DRB Application No.: 07DRB-00007 (P&F)
Project Name EASTERN ADDITION
Agent: Surveys Southwest

**DEVELOPMENT REVIEW BOARD
UTILITY DEVELOPMENT
Standard Comment Sheet**

**CITY OF ALBUQUERQUE
PLANNING DEPARTMENT
January 17, 2007
DRB Comments**

RE: Lot 12, blk 10, Eastern Addition/p&f

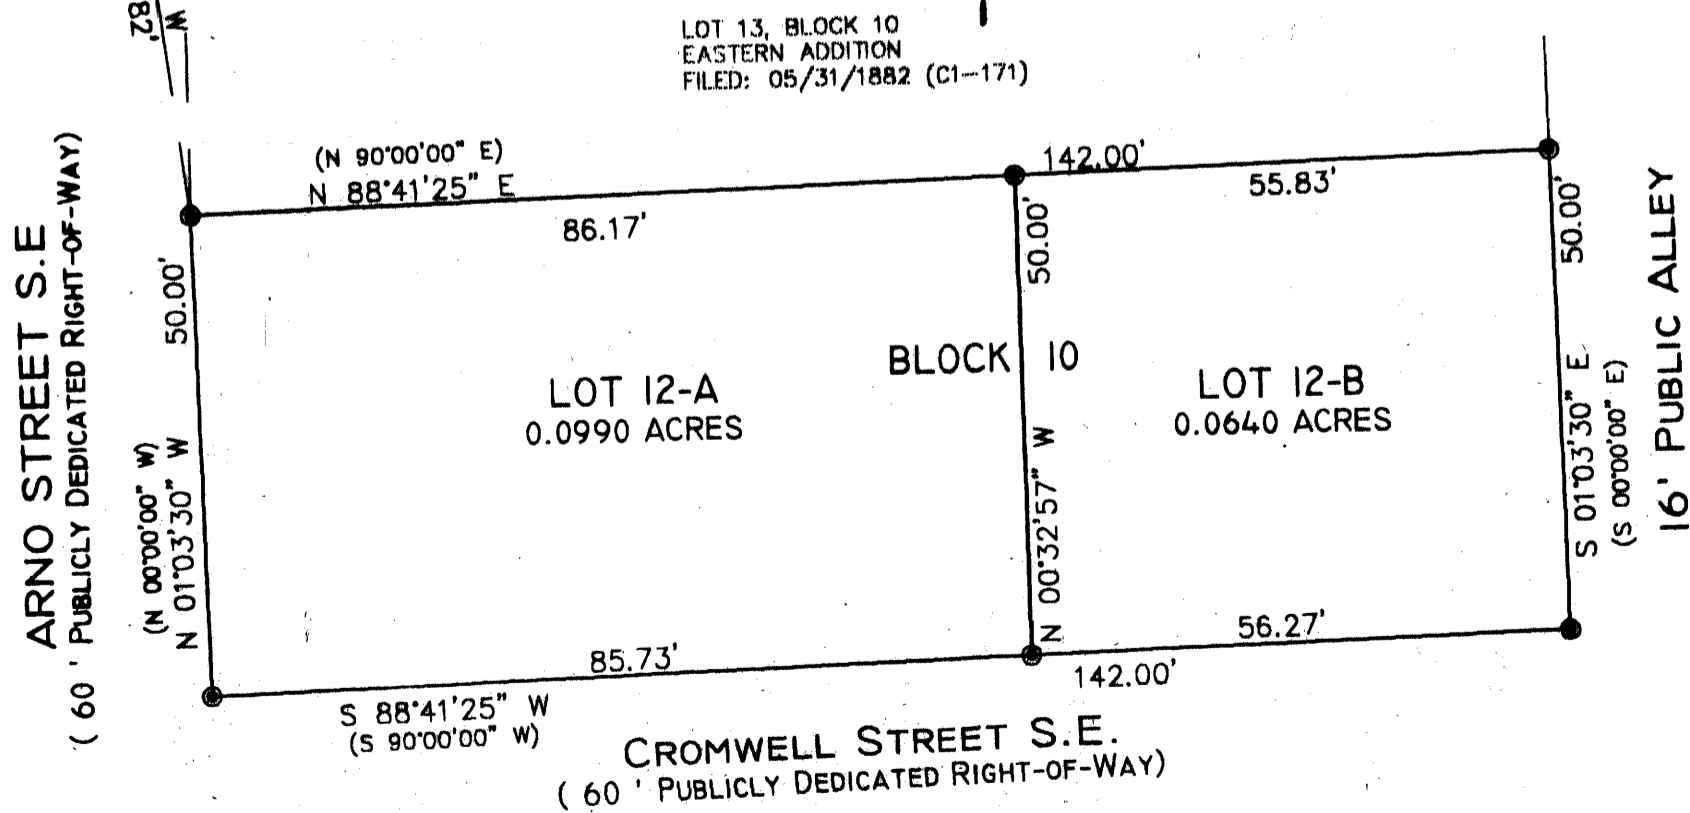
1. This lot split may not work as each lot will need separate water/sewer line connections and accounts. There is no sanitary sewer line in Arno to provide service to the west lot. There may be room to construct a service line along side of the east house, to the alley where the sewer line is located. It may be possible to connect the west lot to a manhole in Arno if one exists along the lot frontage, this needs further investigation.

Make sure that the setbacks per the R-1 zone in apply. A variance may be required.

The purpose of the above referenced property is to propose a division of One (1) existing lot into Two (2) new lots. There are existing dwellings on each lot as proposed, the sewer and water services have been separated.
